Geotechnical Report

4829 Abbott Street East, Ottawa Block 123 – Trail View Subdivision Servicing and Stormwater Management Report

**Reference: 4829 Abbott Street East, Ottawa, ON
Block 123 – Trail View Subdivision
Servicing and Stormwater Management Report
Our File No.: 110037
City File No.: PC2024-0509**

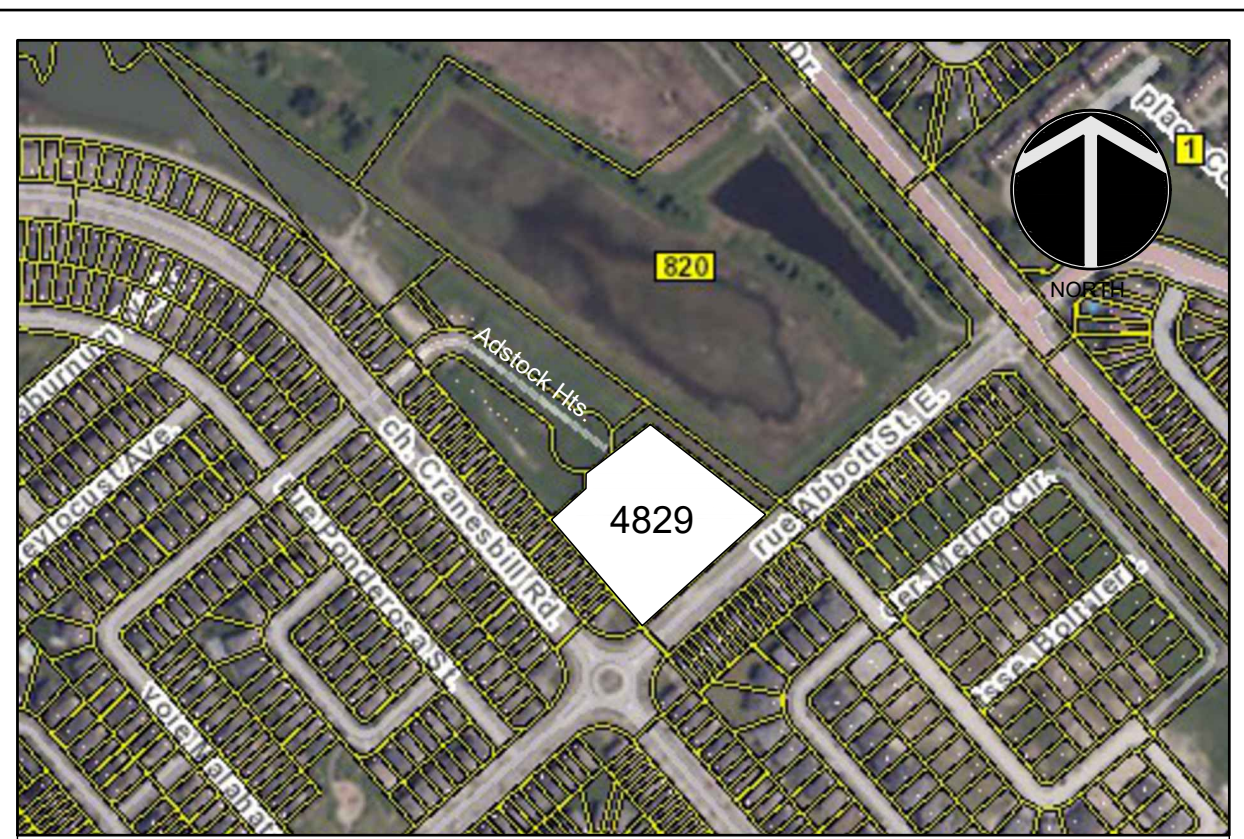
12. *Driveways leading to the garage parking spaces must be a minimum of 2.6m in width to align with zoning bylaw (By-law No. 2026-50) Section 606.*

Response: No change required. Both the Site Plan and Garage Plan indicate that the driveways leading to the garages have a width of 3.2 m (10' 5½"). The Site Plan also demonstrates that a standard width parking space can be accommodated in front of each garage parking space. Please also note that the transition provisions for the New Zoning By-law 2026-50 permit this application to be processed under Zoning By-law 2008-250, as the Site Plan Application was deemed complete and the Minor Zoning By-law Amendment was approved prior to March 11, 2026 (date of enactment).
